Ribble Valley Borough Council

DELEGATED ITEM FILE REPORT - REFUSAL

Application No:	3/2014/0780
Development Proposed:	Proposed window at ground floor on the side elevation of 4 Park mews, Gisburn, BB7 4ES.

Proposed Side Elevation
Scale 1:100

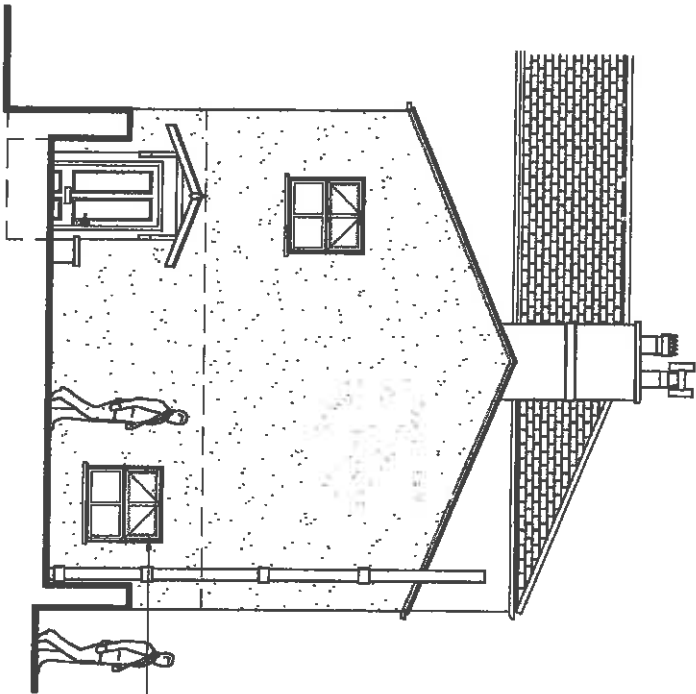
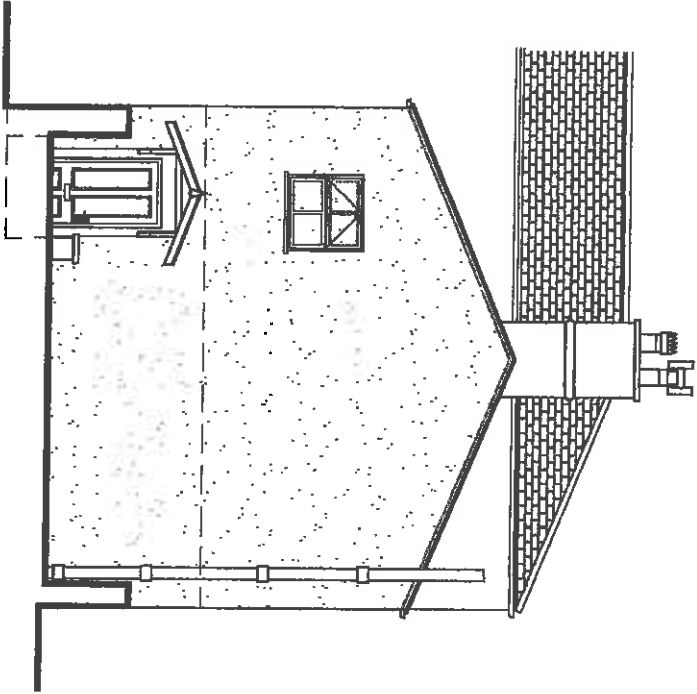
The proposed works consist of the insertion of a new ground floor window opening into the South West facing gable end of the property. The new opening will be created at ground floor level adjacent to the existing entrance door and this will serve the living room.

Planning permission has previously been granted for a first floor window opening directly over the existing entrance door which serves an existing bathroom, planning application 3/2013/0240P. This window has been inserted in accordance with the details approved and is narrower in width than the window illustrated on both the existing and proposed elevations drawings submitted with this application.

At present the existing door on the gable elevation is relatively inconspicuous. In contrast, the first floor window recently allowed is more conspicuous; however, the dimensions of this window are smaller than the window being proposed. In addition, these present openings by virtue of their scale and positioning to the far left hand side of the gable elevation leave the right hand side of the gable unadorned respecting the solid to void ratios of this historic gable.

These openings, more so the ground floor door, is obscured from long range views by the neighbouring building, Pimlico House, when viewed from the main road to the West. An existing boundary wall also aides to obscure the presence of the door. The proposed new ground floor window opening would, in my opinion by far more prominent. The ground floor window, due to its positioning would not benefit from the screening that Pimlico House provides to the existing door and would further detract from the solid to void ratios present on this property.

The proposed works, including the enlargement of the first floor bathroom window, would be an insensitive modern addition to the building and would therefore be damaging to the historic fabric of the building, a designated heritage asset. The addition of a further new window opening in this prominent gable end elevation would further erode and dilute the historic character of this designated heritage asset and this part of the conservation area detracting from its character and appearance and diluting the significance of the conservation area.
